GRADING AND EROSION CONTROL PLAN

JUDGE ORR ROAD RV PARK AND STORAGE

EL PASO COUNTY, COLORADO

FIGURE OS-2 TYPICAL OUTLET STRUCTURE FOR FULL SPECTRUM DETENTION
OUTLET STRUCTURES DETAILS
NOT TO SCALE

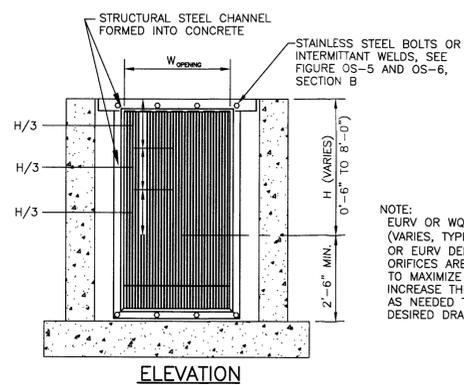
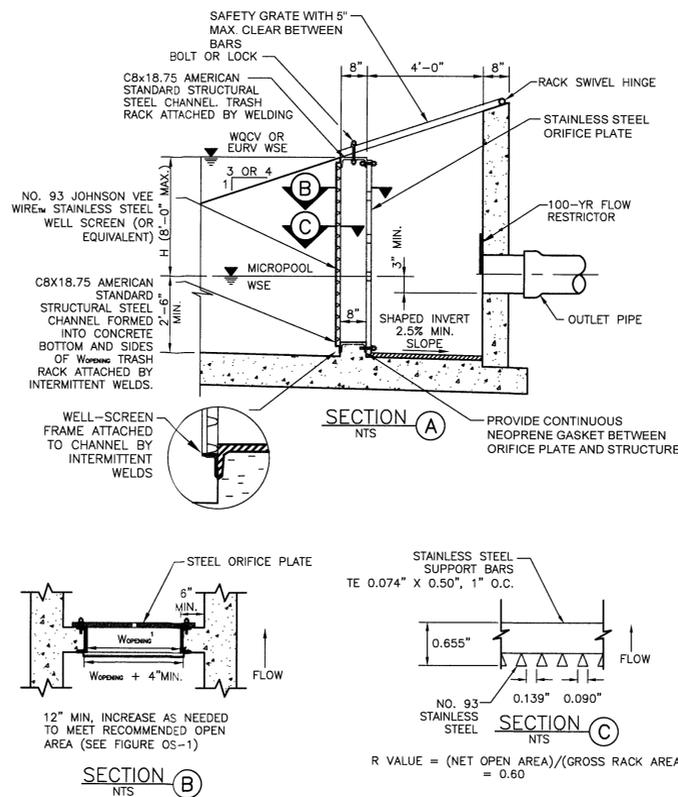
Outlet Structure will be reviewed with the resubmittal. Comments on the drainage report outlet design worksheet will revise the component elevations and sizes

SEDIMENT BASIN PLAN

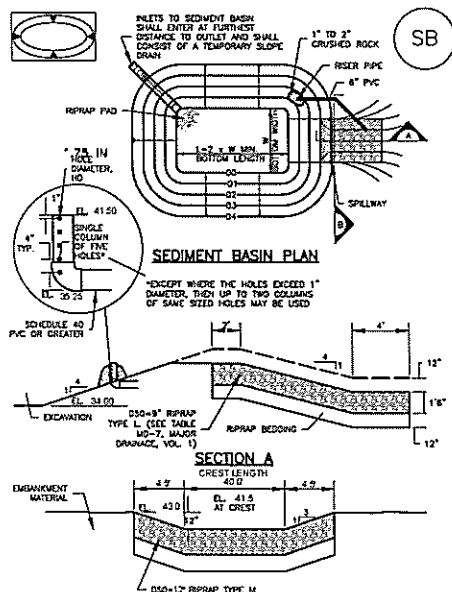
Identify the required temporary sediment basin pond volume. Based on the pond configuration, the relative elevation of 3.00 from the bottom of pond does not appear to provide the required volume. Unresolved.

use actual elevation. Unresolved.
